## KITTITAS COUNTY COMMUNITY DEVELOPMENT SERVICES

### **RE: Shoreline Exemption - SX-24-00022– Deemed Incomplete**

PARCEL R  
SEC. 1, T. 18 N., R. 17 E., W.M.

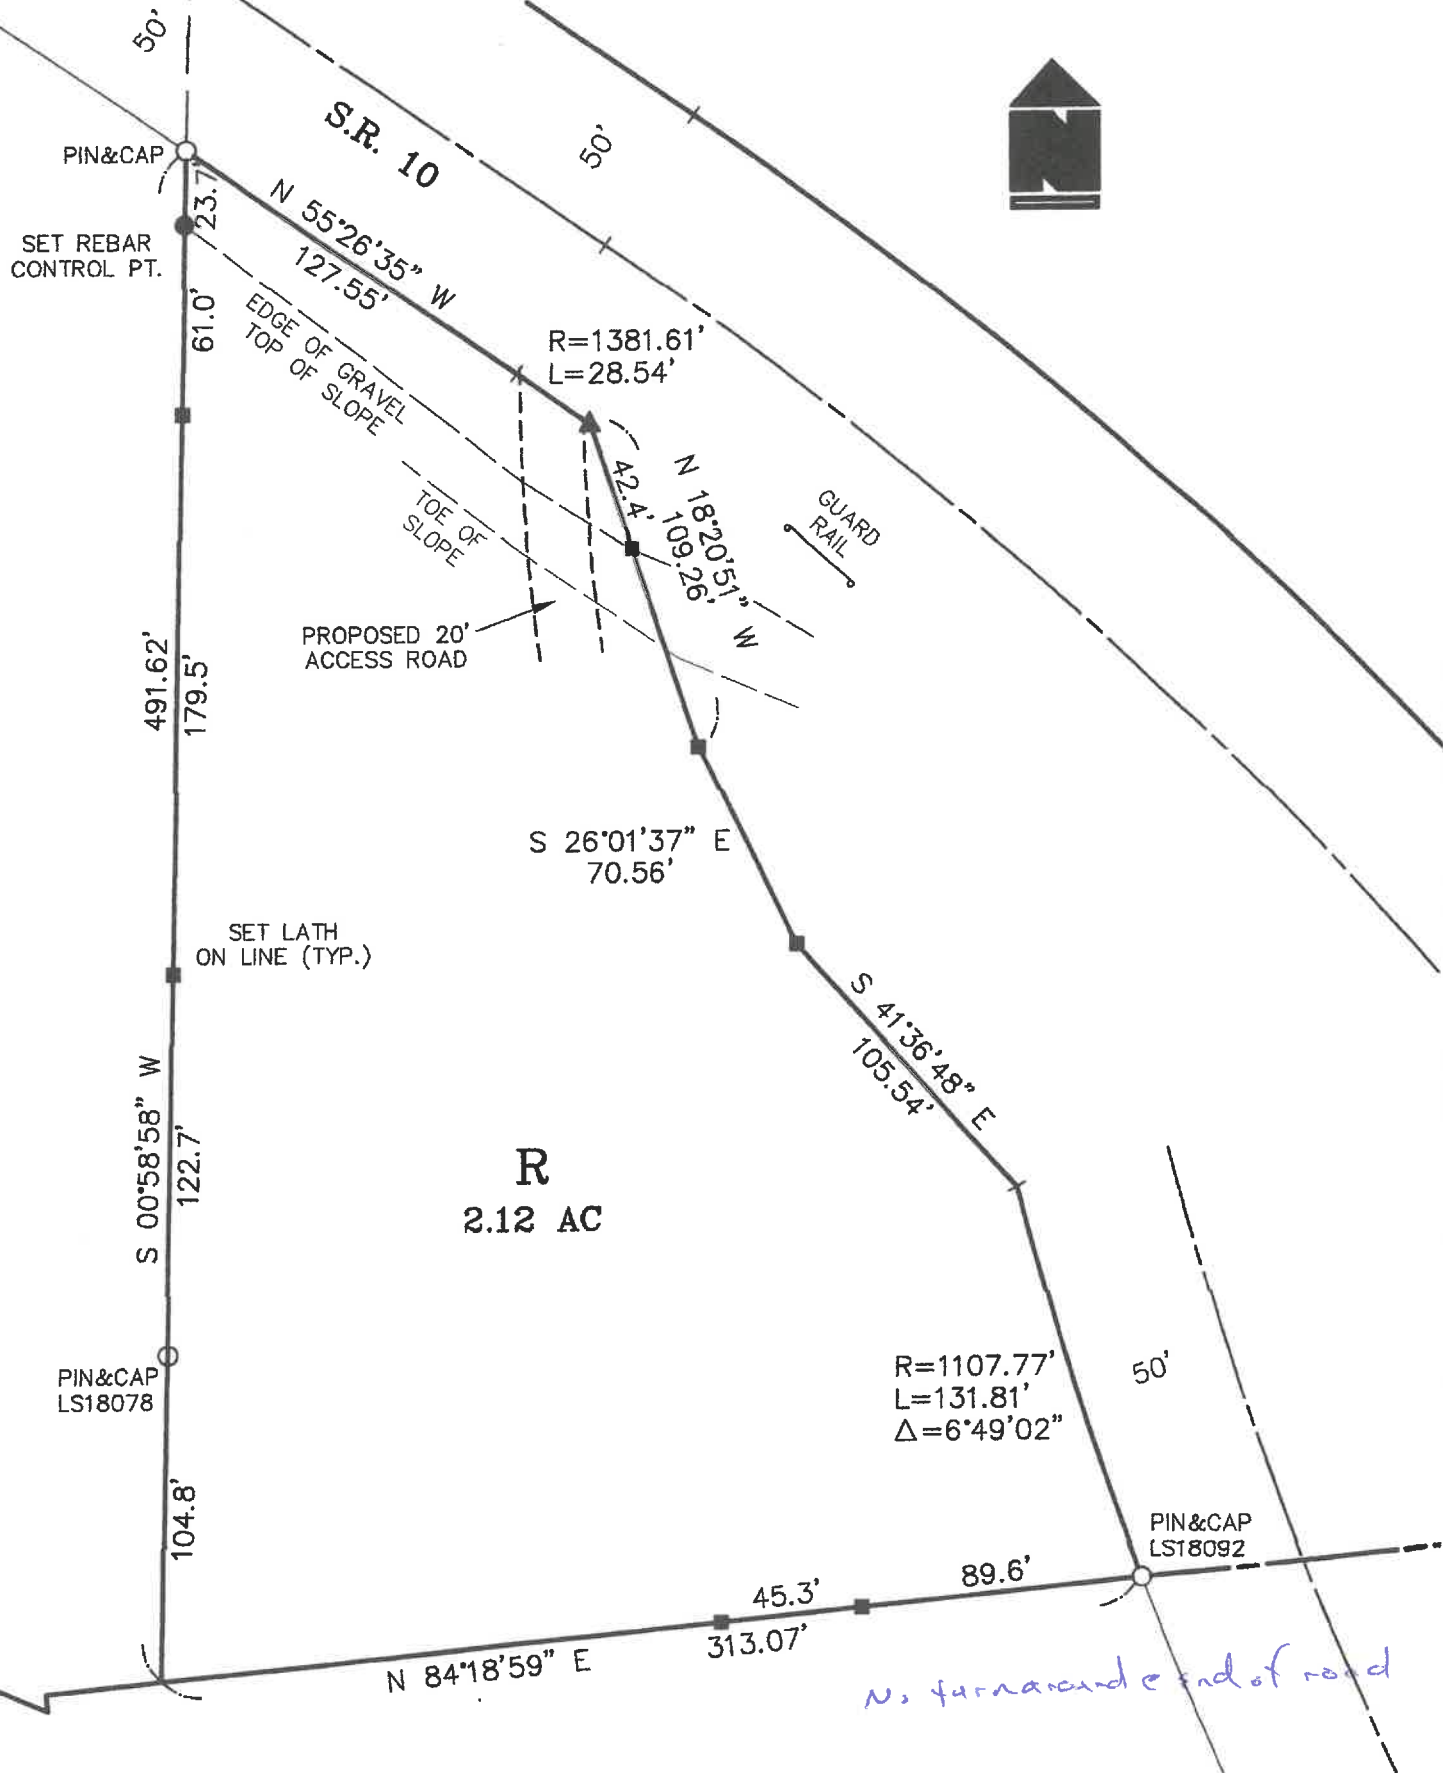
1. Updated site plan showing the dimensions & location of the proposed driveway to include starting point, full driveway, ending point, length, width, distance from Ordinary High-Water Mark, distance from edge of Floodway to the driveway, and distance from each lot line to the edge of the driveway.
